Job No. 193940

July 24, 2026

Re: Response to:
Colorado Geological Survey Review Comments, dated December 22, 2025
Triple H Ranch
EPC Schedule No. 3300000168 and 3300000388
El Paso County, Colorado

PRELIMINARY PLAN

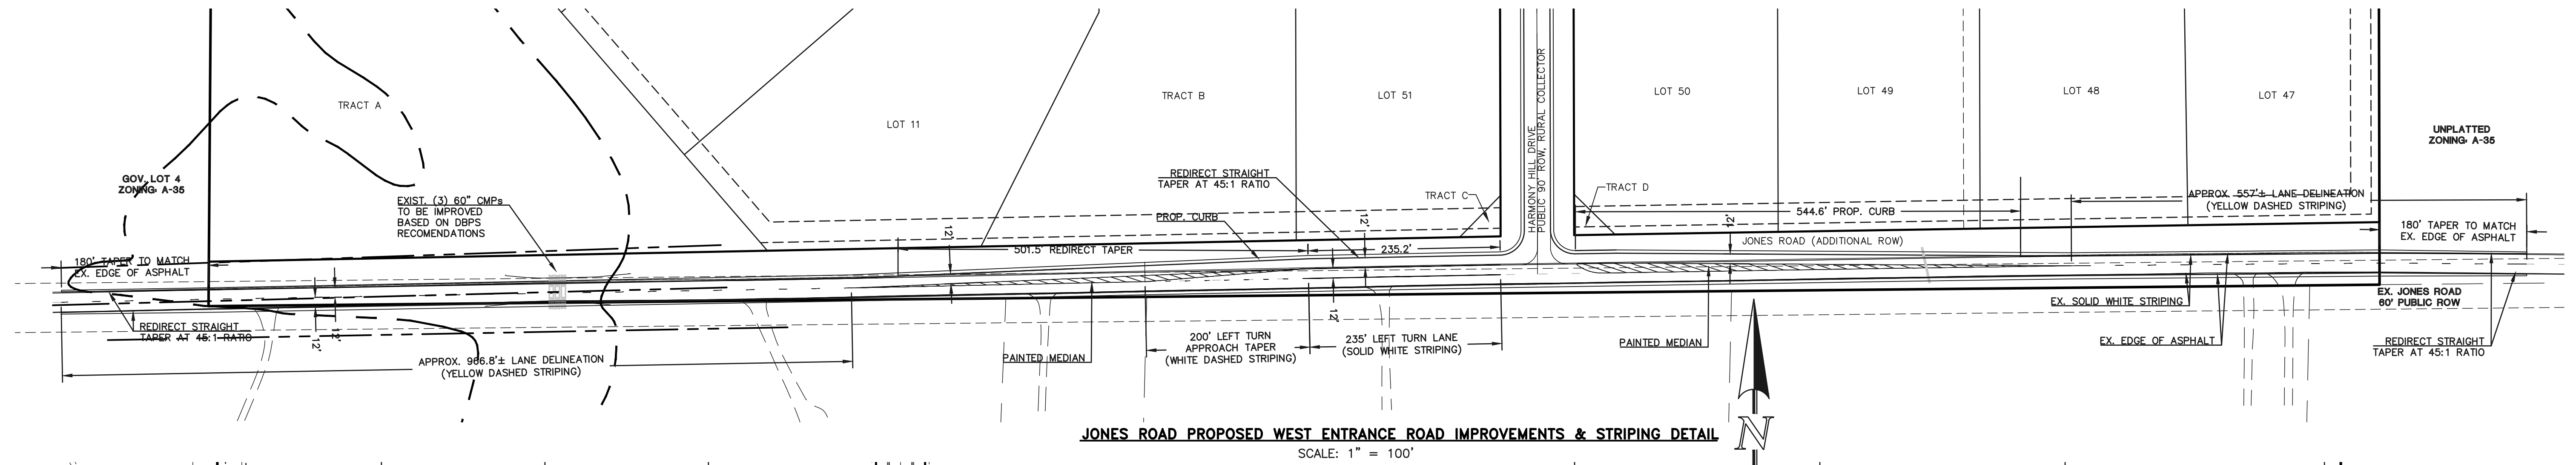
1. The preliminary plan should reference RMG's report for the Triple H Ranch.

2. The Geologic Hazard Note (Note 14) on the preliminary plan should be updated to list all of the geologic hazards associated with the site and mitigation measures.

The preliminary plan reference has been updated to reflect RMG's report last dated July 24, 2026.

The Geologic Hazard Note has been updated on the preliminary plan. The note presented to the Client reads as follows:

SOIL & GEOLOGY, CONDITIONS, CONSTRAINTS, & GEOLOGIC HAZARD NOTES:

A Soil and Geology Study for Triple H Ranch located within El Paso County, Colorado, was completed by RMG Engineers (Job No. 193940), last amended on July 24, 2026. The overall development area has been found to be impacted by the geologic constraints listed below.

- Potentially expansive and compressible soils
- Flood prone area
- Faults and seismicity
- Radon

Due to the size of the lots, mitigation of the identified constraints is most effectively accomplished on a lot by lot basis.

- A site-specific subsurface soil investigation is to be completed for each lot, water tank and treatment building prior to permitting.
- A No Build Zone is located near the southwest corner of the site. The location of the residence and OWTS on Lots 11-16 are to remain outside the No Build Zone.

- A year-long groundwater monitoring program is to be finalized April 2027. To date, groundwater has not been observed. Once the monitoring is complete, the feasibility of basement construction is to be determined.

- Conventional shallow foundations consisting of a standard/spread footing/stemwalls are anticipated to be suitable for the proposed residential structures. A perimeter drain is recommended around portions of the structures which will have below habitable space or storage space located below the finish ground surface. This includes crawlspace areas but not the walkout trench, if applicable.

- Appropriate surface grading and drainage should be established during construction and maintained (over the life of the structure) by the homeowner. Additional mitigation measures can be found in said report, PCD File SP254, available at the El Paso County Planning and Community Development Department.
